**Stage 1 Concept DA & Demolition for 52 Phillip Street, Sydney (SSD-10464)
Public Exhibition**

Thank you for your correspondence via the Major Projects Portal on 13 April 2021, requesting Transport for NSW (TfNSW) to review and comment on the above.

Attachment A – Items to be addressed as part of the Applicant’s Response to Submissions

Appendix D

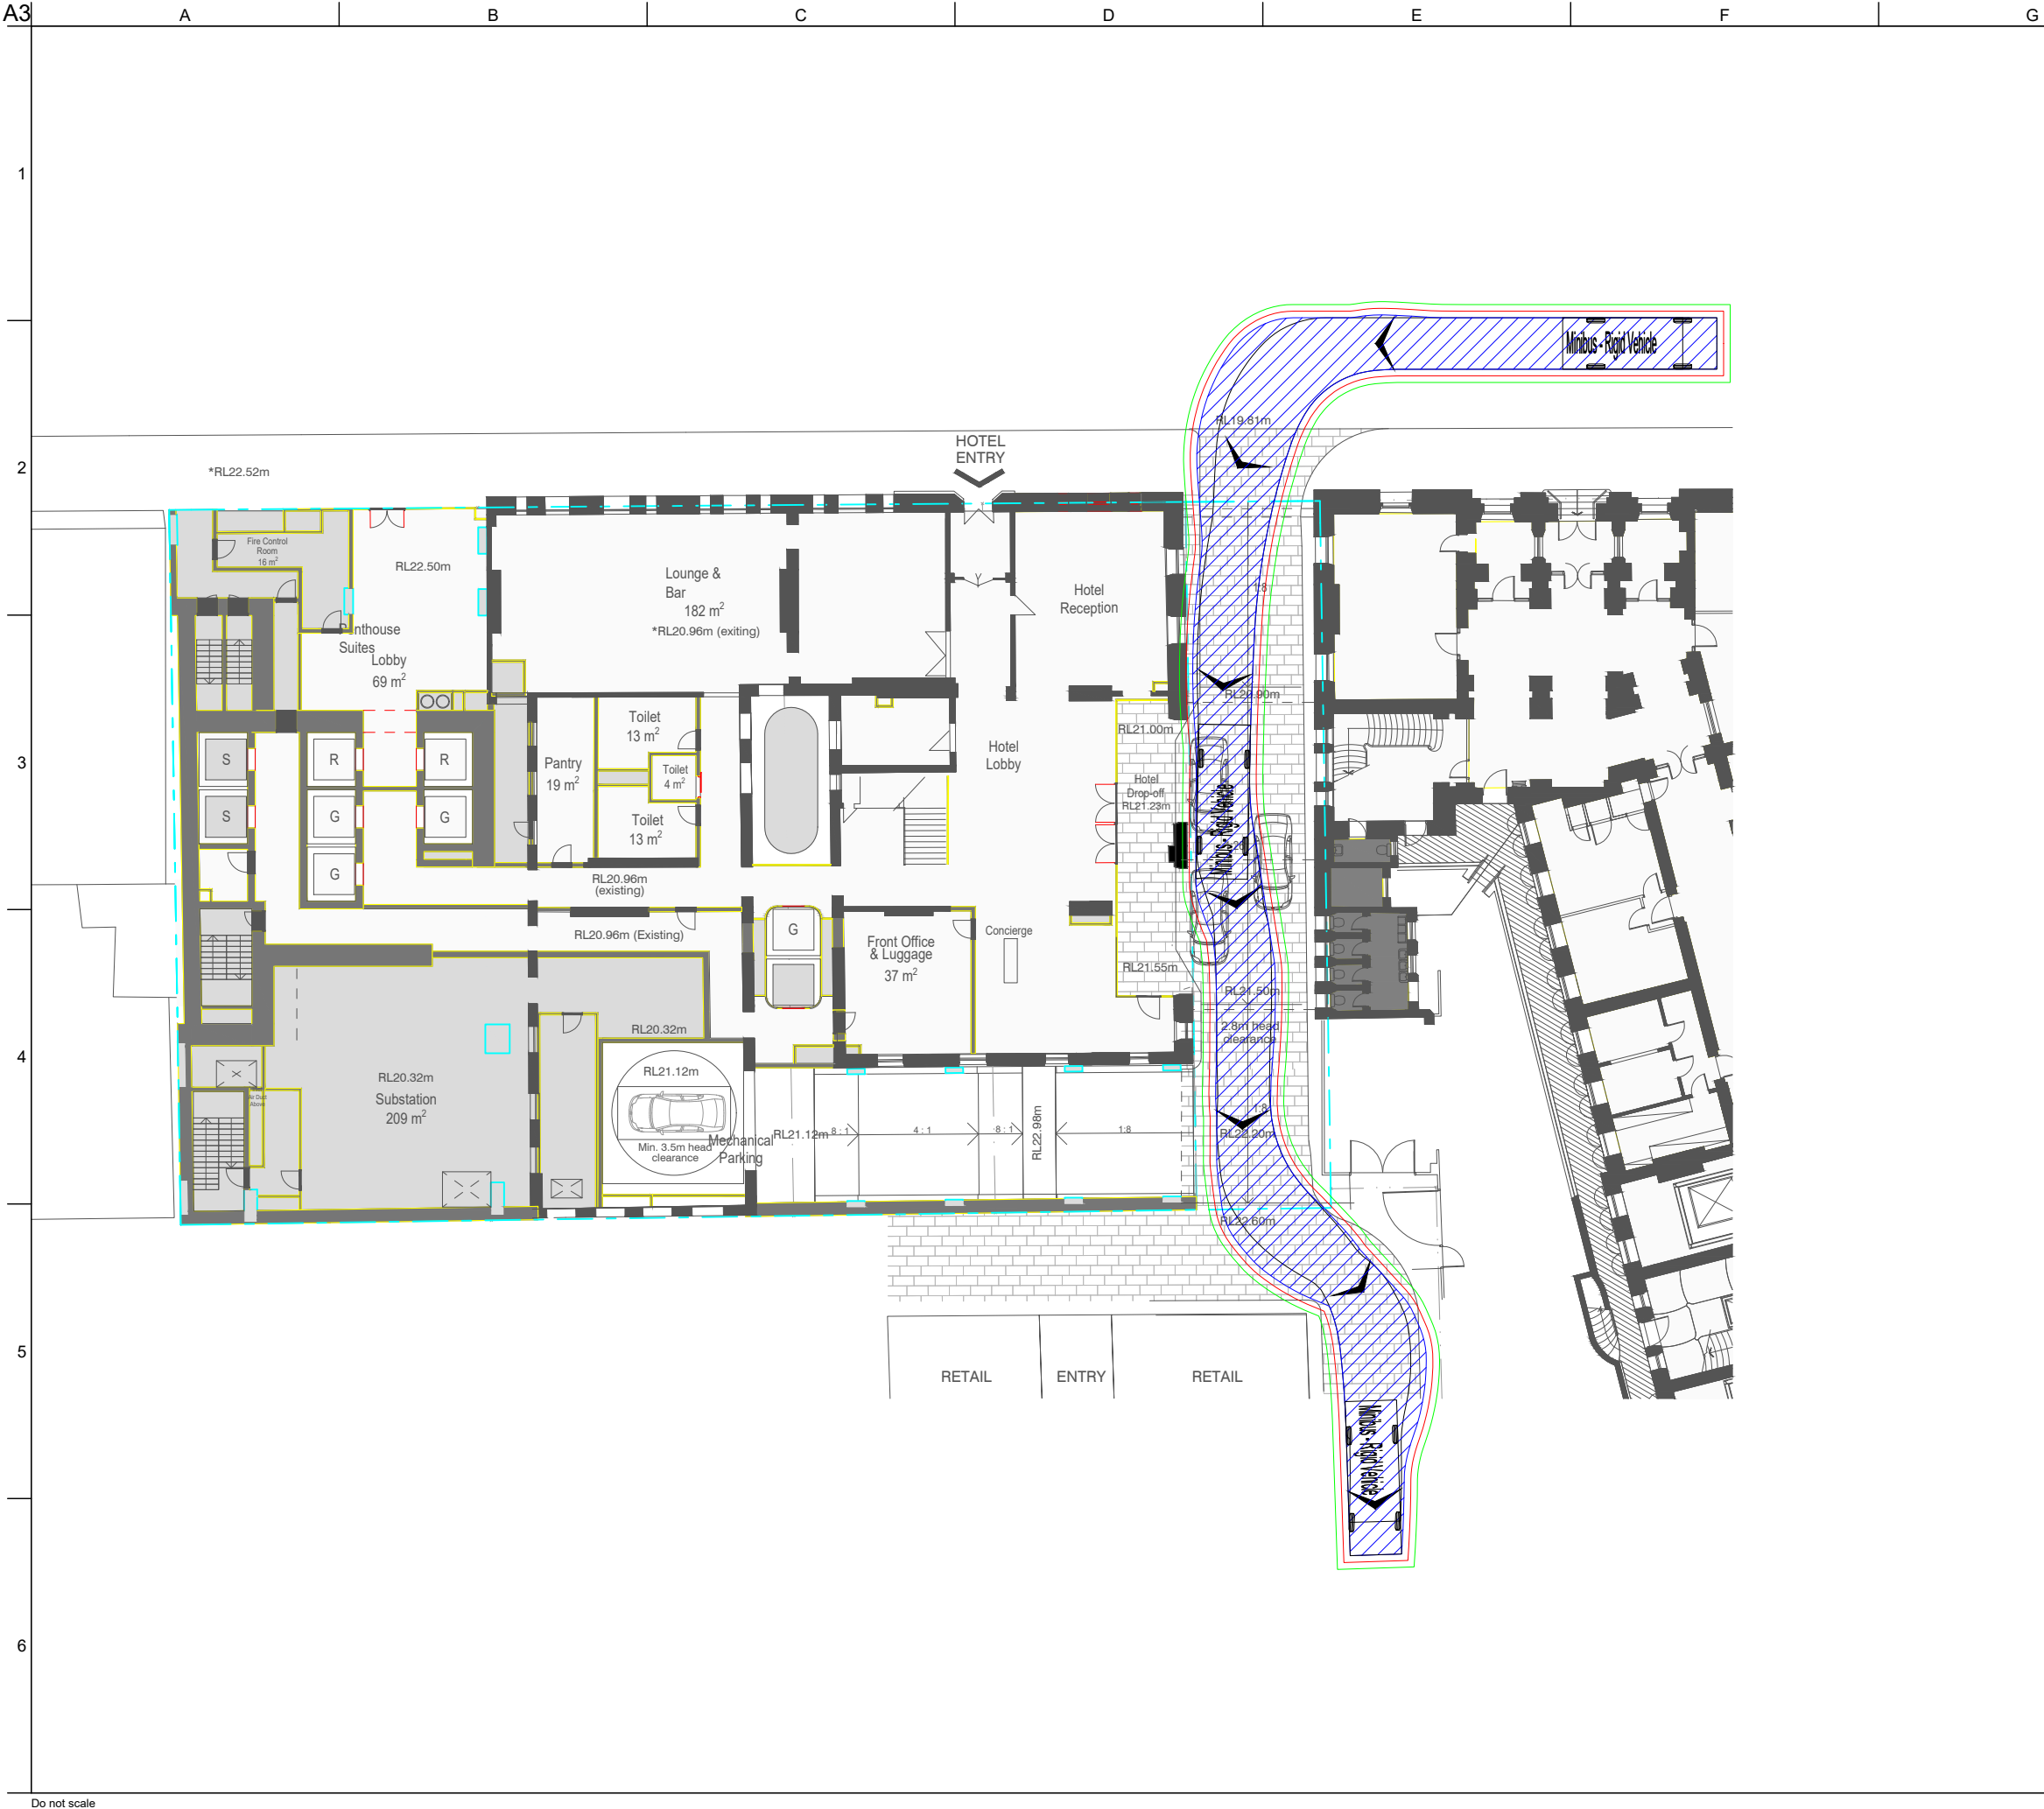
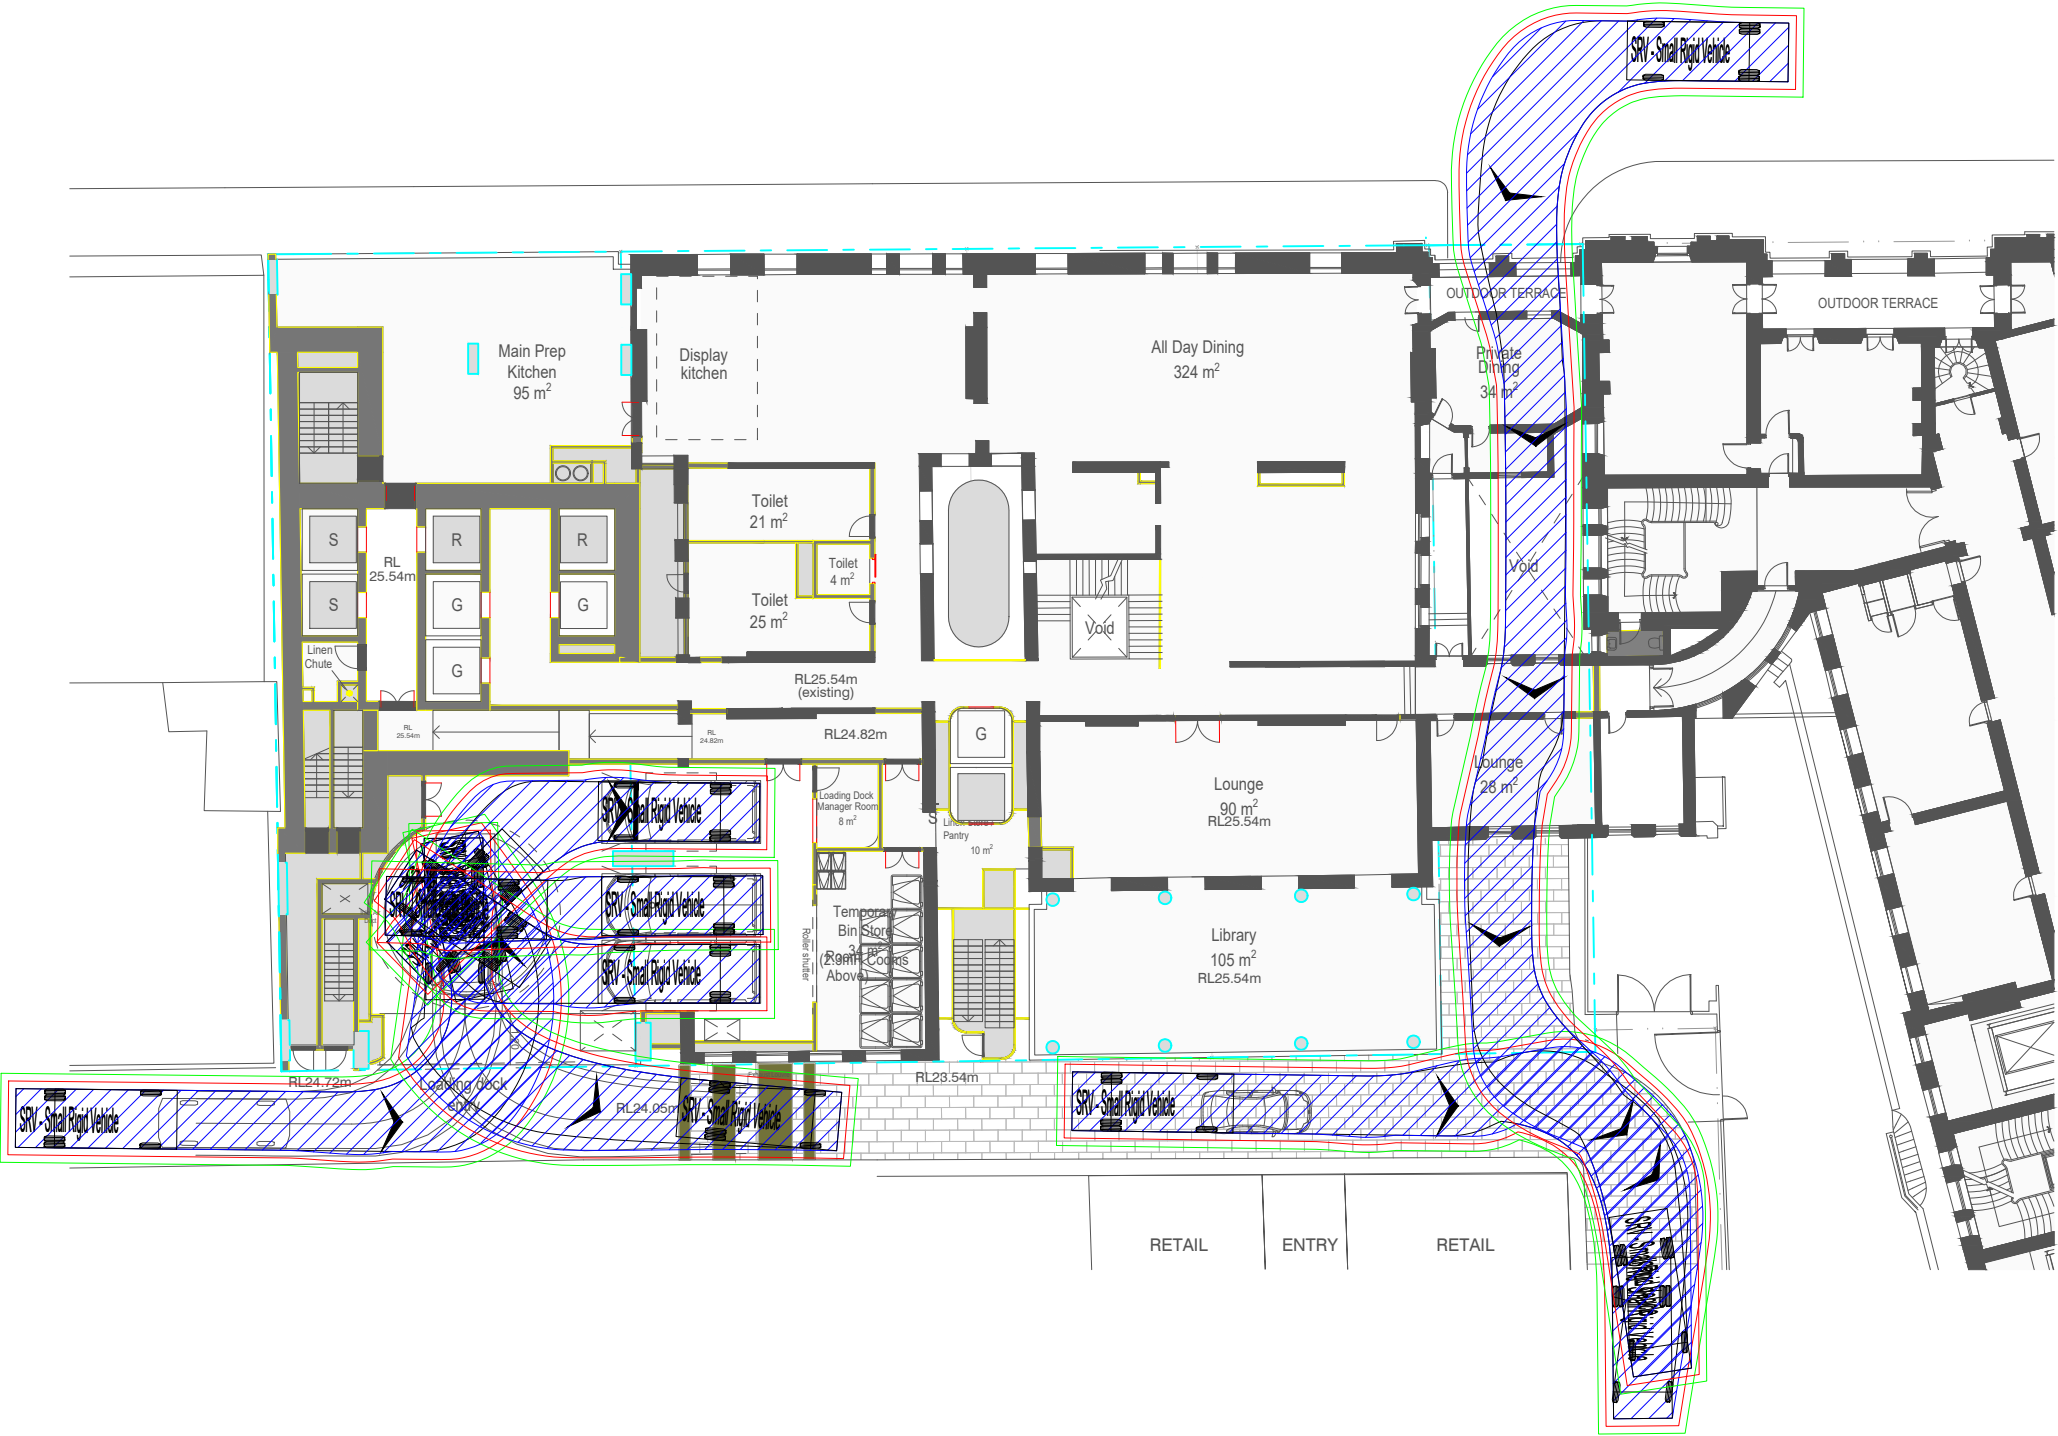
- Appendix D the Transport Impact Assessment provides swept path analysis for vehicles accessing the site. A swept path diagram for a Small Rigid Vehicle of 3.5m in height to turn from Phillip Street into Phillip Lane is shown. The existing head clearance height of the Phillip Lane tunnel structure is 2.8m which limits the ability of Small Rigid Vehicles to undertake the illustrated left turn from Phillip Street; and

- Figure 20 the Transport Impact Assessment shows that two vehicles would be able to queue within the site whilst Appendix D provides a swept path diagram for passenger vehicles entering/exiting the site which shows only one queuing vehicle could be accommodated within the site.

- Confirm that the existing head clearance height of the Phillip Lane tunnel structure would permit Small Rigid Vehicles to undertake the illustrated left turn from Phillip Street; and
- Waiting area for the vehicles to be served by the lift needs to be marked based on results of the swept path analysis.
